75 York Street Bathroom Renovation Comments Summary

Received 12/18/2018

Resubmitted 01/03/2019

Reviewed for Code Compliance
Permitting and Inspections Department
Approved with Conditions

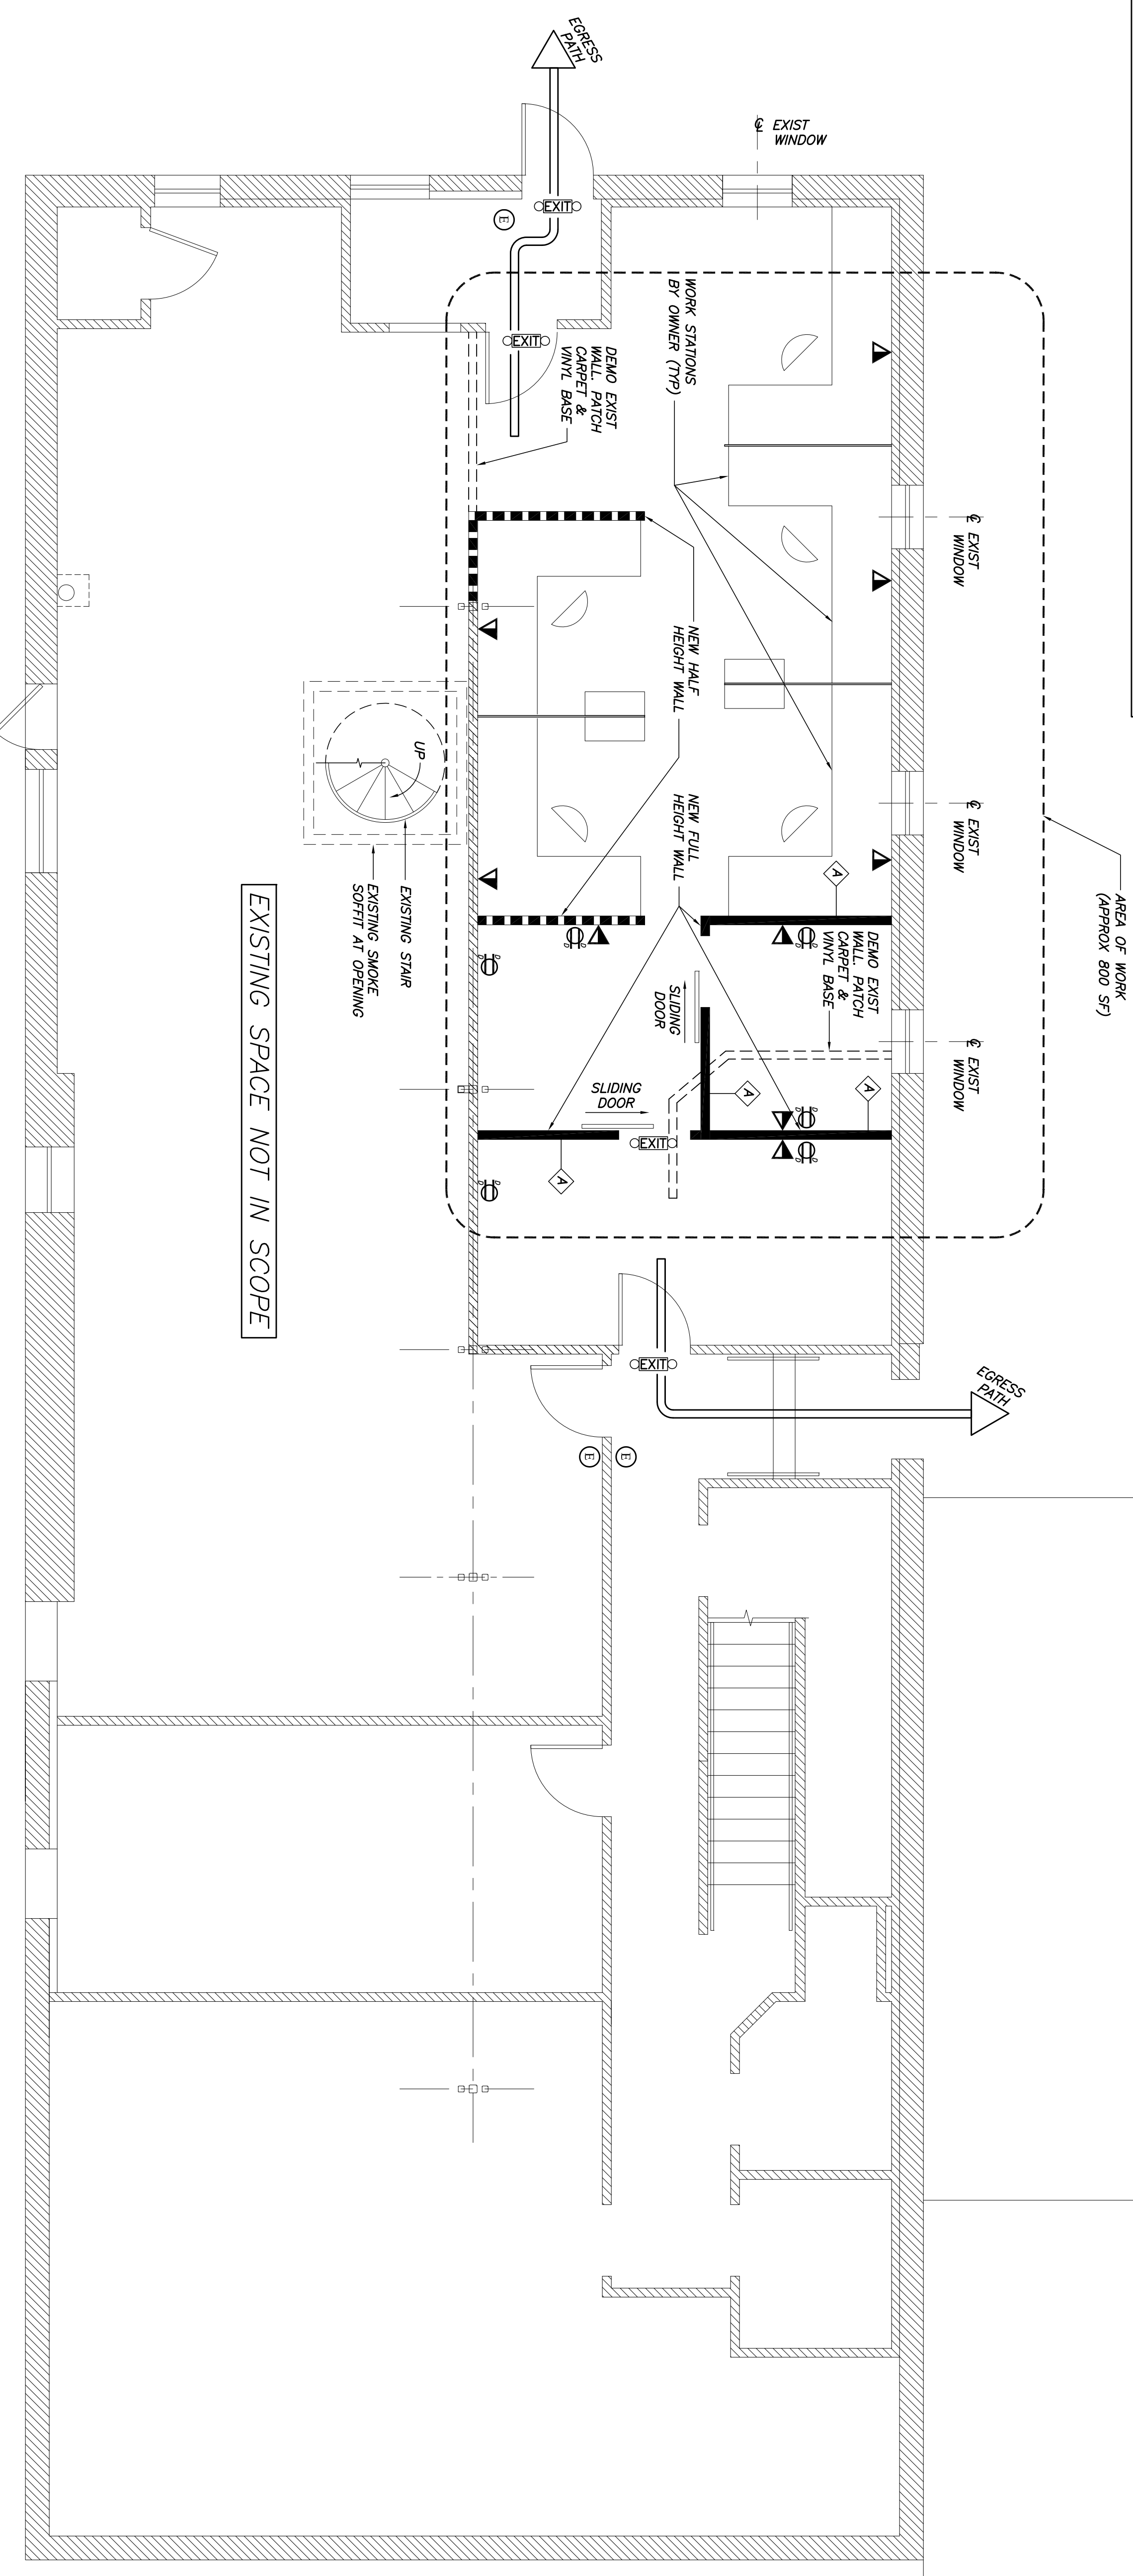
Element Comments: Please show compliance with ADA Standards Sections 213.2 and 603.

Element Comments: Is this toilet room compliant with ADA Standards? (fixtures, clearances, grab bars, dispensers, etc.)

Element Comments: 50% of multiple single user toilet rooms must comply with ADA Standards Section 603. This one appears not to meet required water closet clearance.

Element Comments: This door needs to be rated to 1 hour. This closet is being added to part of the exit access and will need to be rated. 39.2.1.1 NFPA 101 2009

Element Comments: These walls need to be rated to 1 hour as well. This closet is being added to part of the exit access and will need to be rated. 39.2.1.1 NFPA 101 2009

Applicant Update: Please see revised toilet configuration on revised sheet A100.

Applicant Update: Existing toilet G07 is ADA compliant and has grab-bars. Please revised sheet A100.

Applicant Update: Existing toilet G06 is not ADA compliant. Existing toilet G07 and New Toilet G09 are to be ADA compliant to satisfy the 50% requirement. Please see revisions on sheet A100. Certificate of Occupancy obtained 10/10/2003 has been included for reference.

Applicant Update: Please note Closet G10 has been eliminated. Please revised sheet A100.

Applicant Update: Please note Closet G10 has been eliminated. Please revised sheet A100.
